Re: Glads Holding – 4911 Chappell NE, Engineer's Stamp dated 3-22-07
Tracts 9C of the Renaissance Center, (F16/D52)

Re: Glads Holding – 4911 Chappell NE, Engineer's Stamp dated 2-22-07
Tracts 9C of the Renaissance Center, (F16/D52)

RE: Glads Holdings Office Building (F16/D52)

Re: Glads Holding – 4911 Chappell NE, Engineer's Stamp dated 1-24-07
Tracts 9C of the Renaissance Center, (F16/D52)

GRADING AND DRAINAGE PLAN

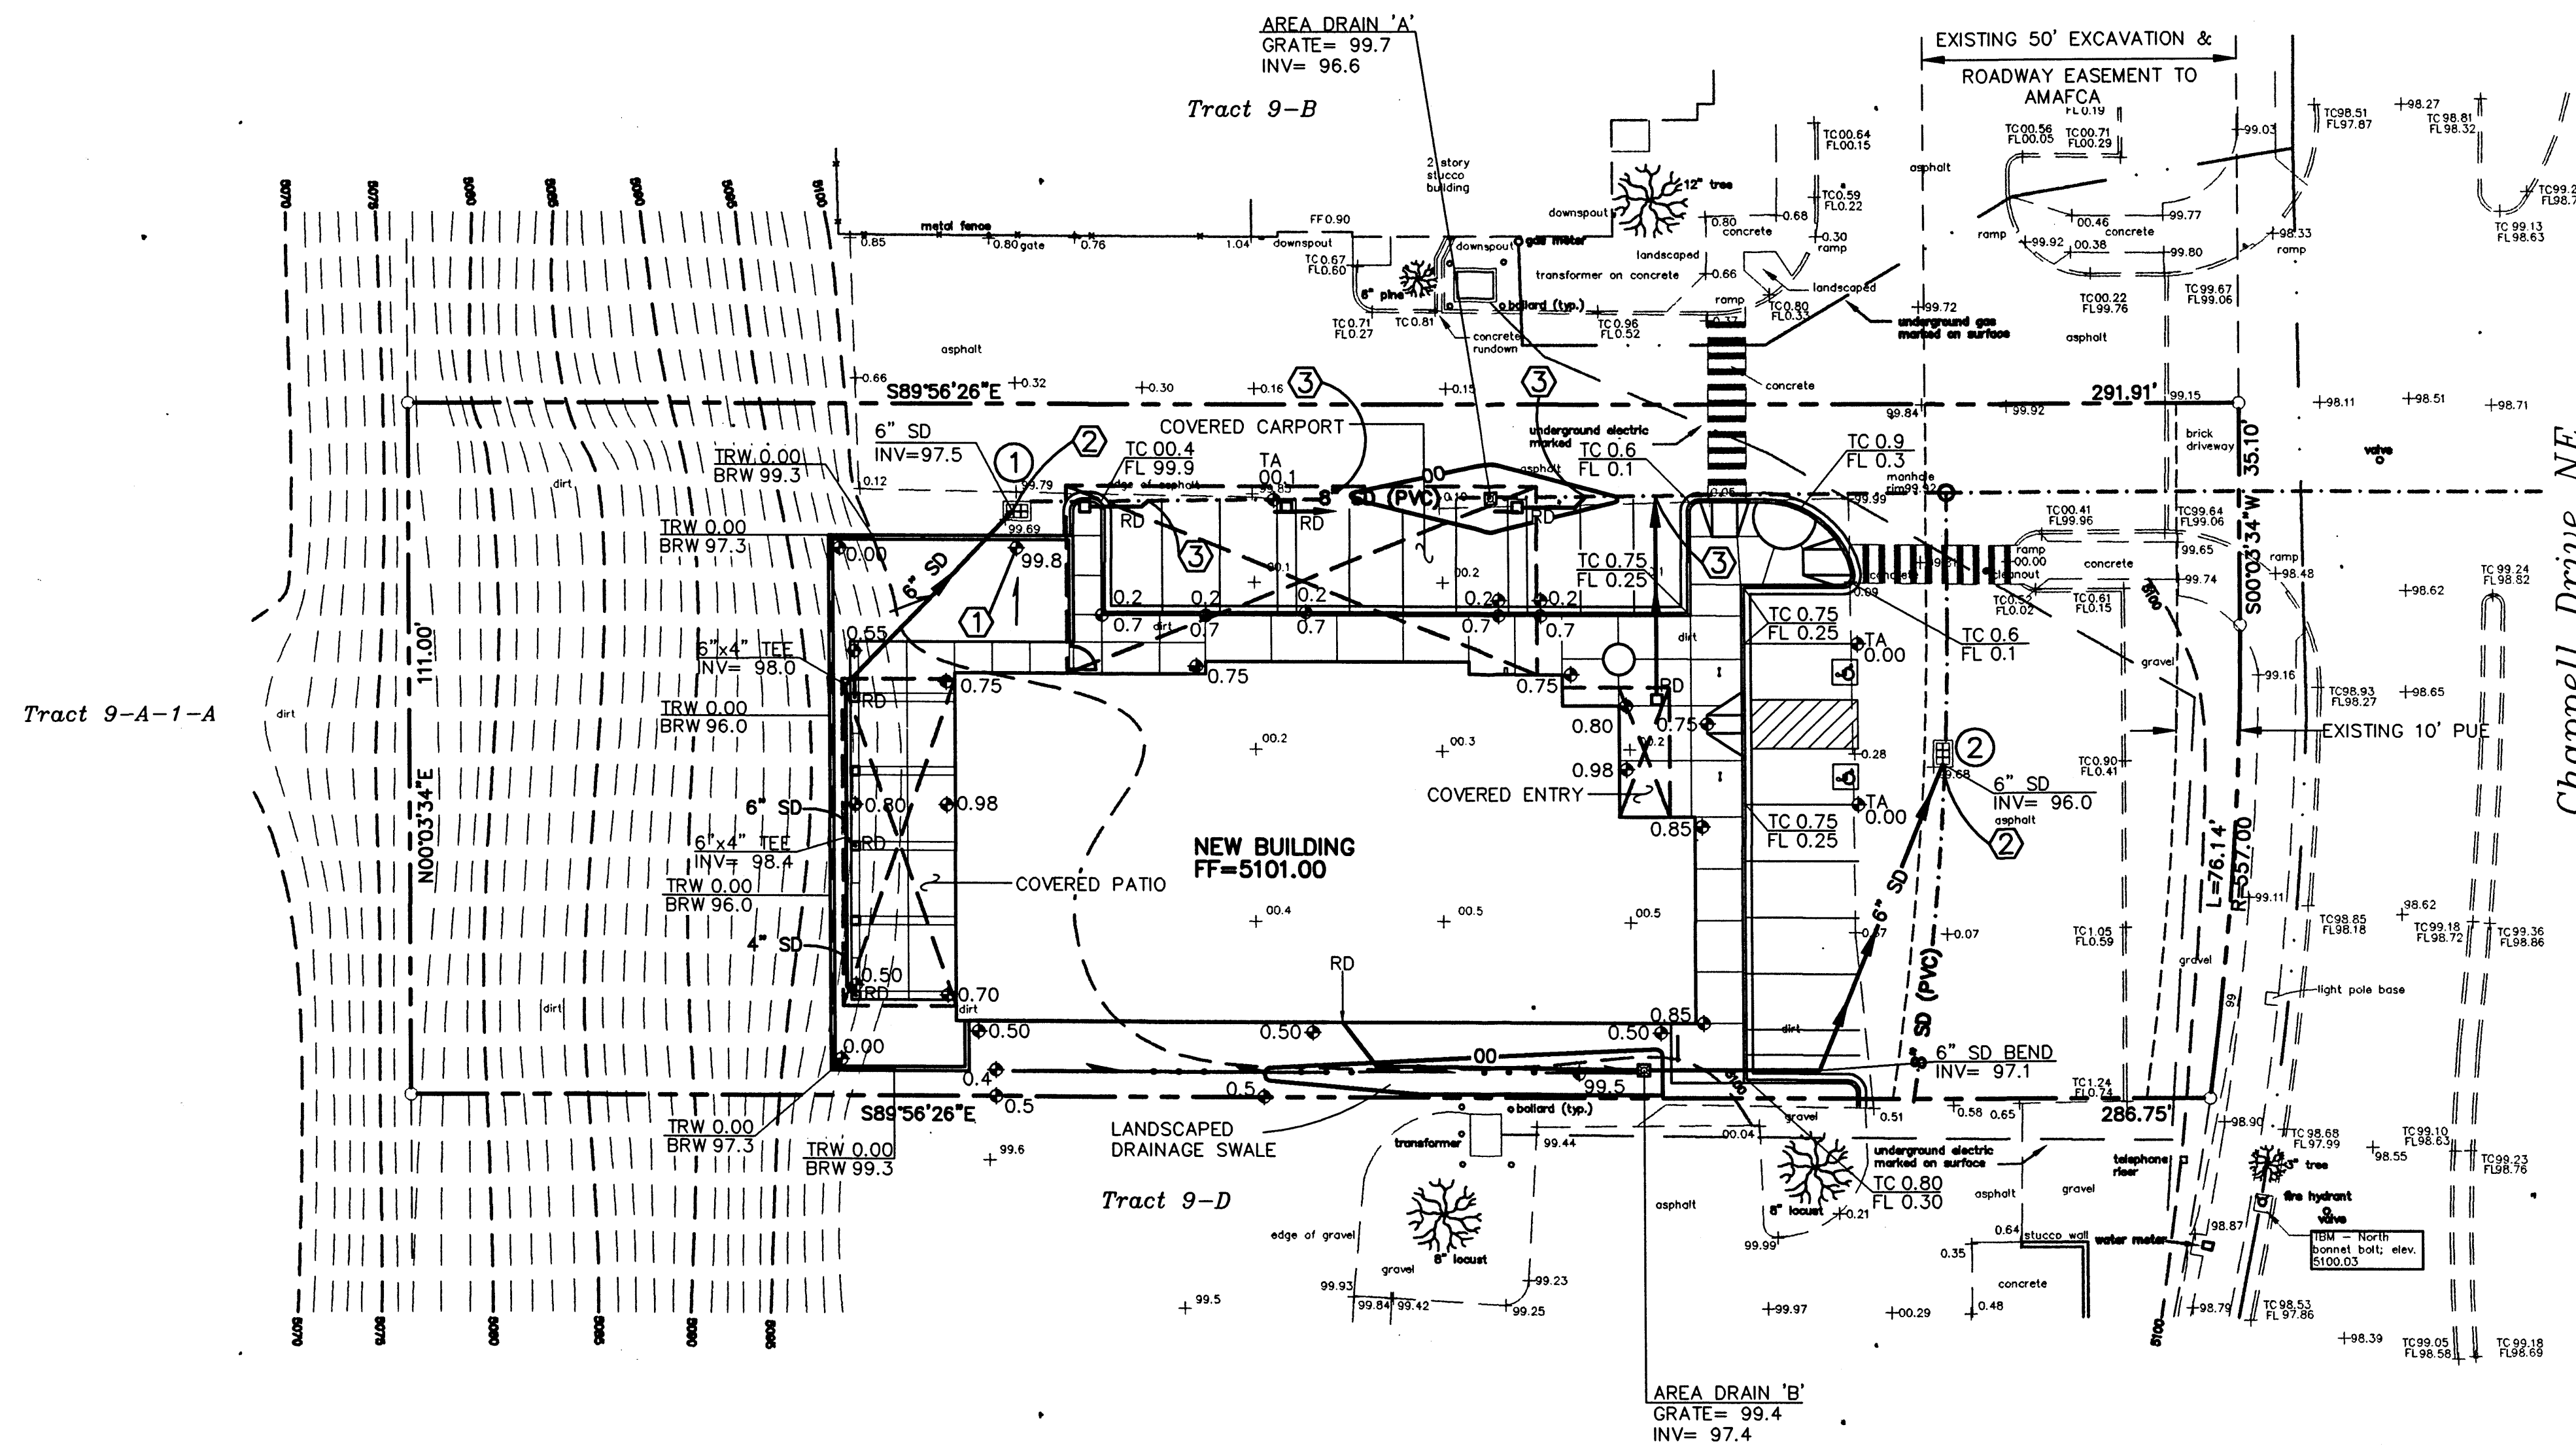
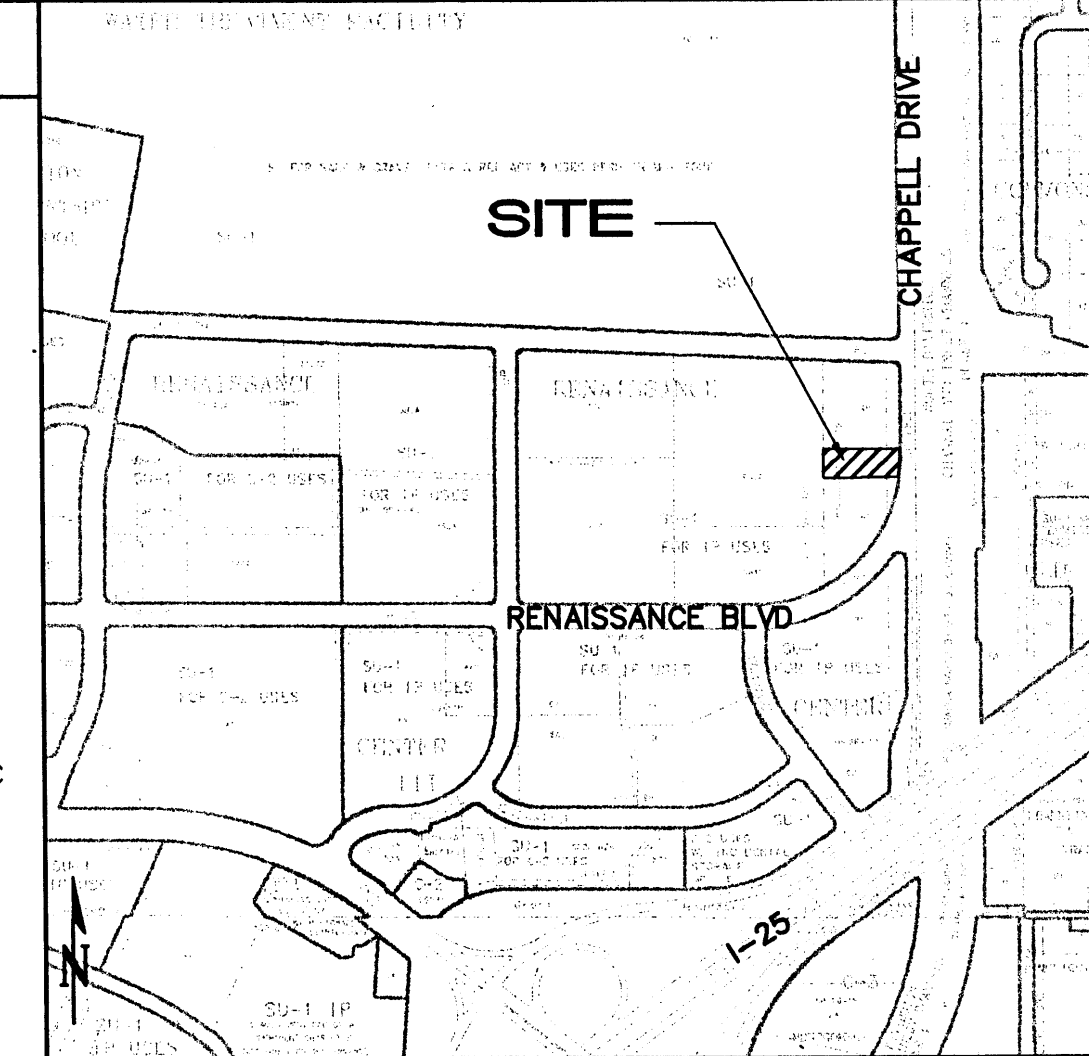
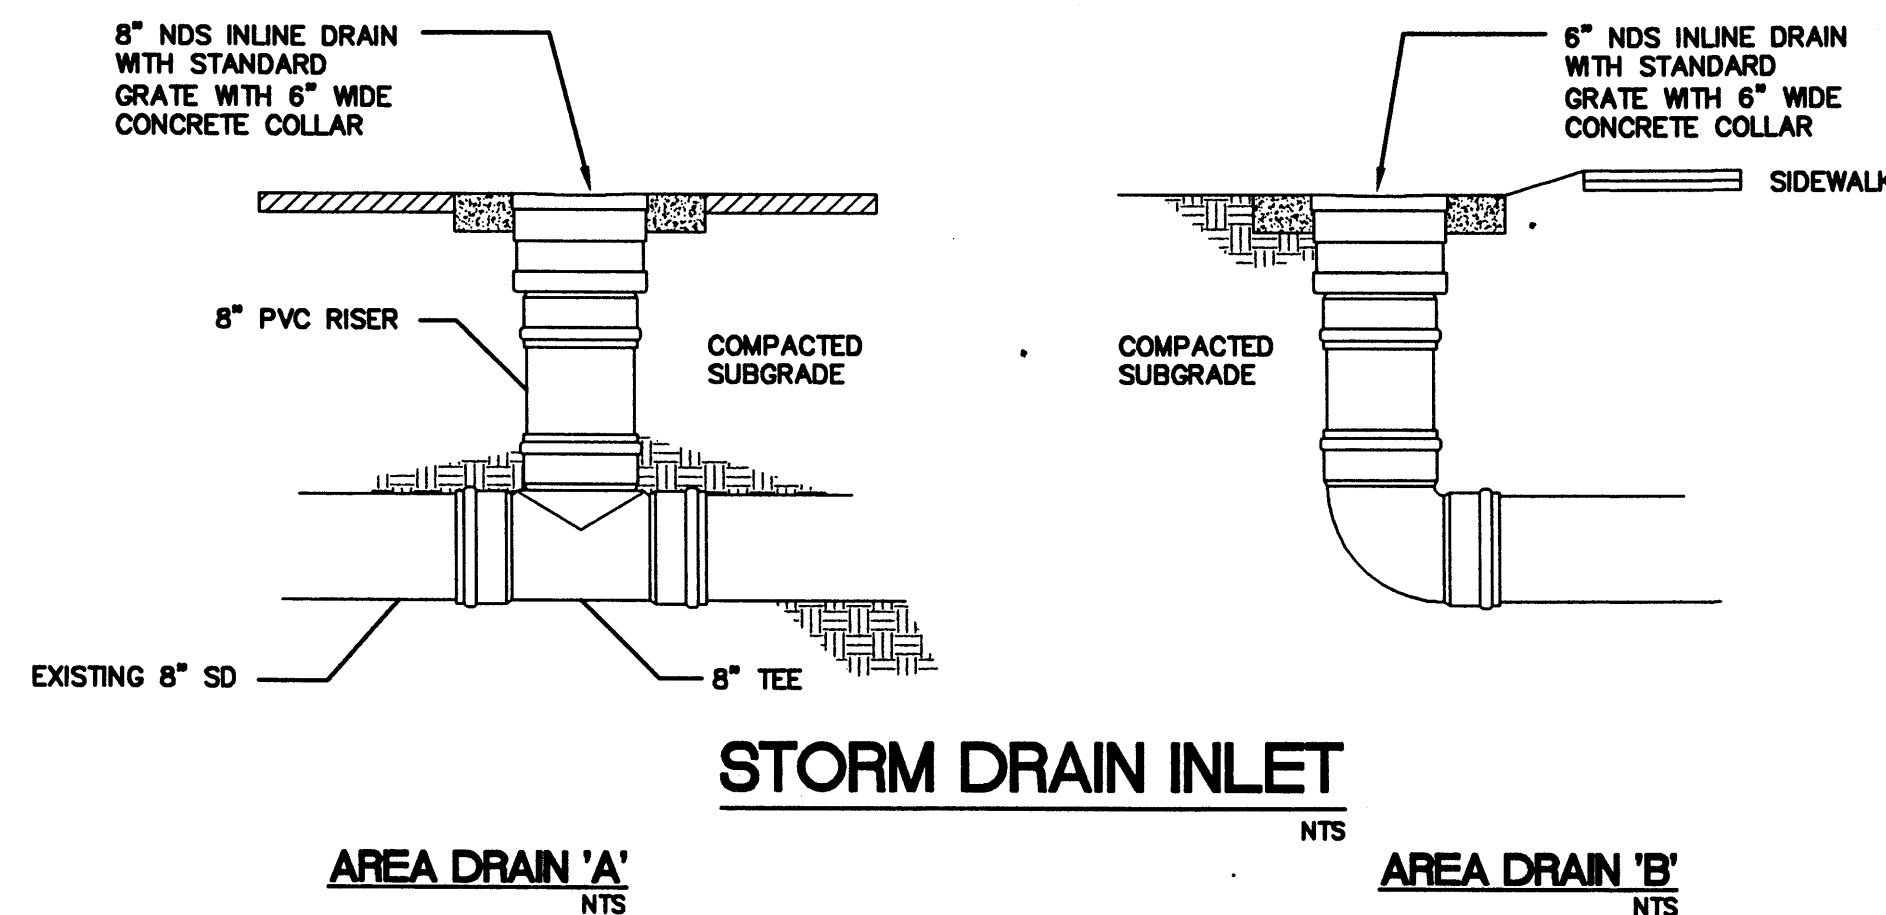
- Your curb detail indicates a modified 8-inch curb with a level gutter pan but the flow line and top of curb elevations on the plan indicate a 6-inch curb. Please clarify.
- With your revised submittal, please include a legend entry to specifically define the two (2) north – south dashed line types (adjacent to the existing, 8-inch storm drain and parallel to the eastern lot line) used on the plan.
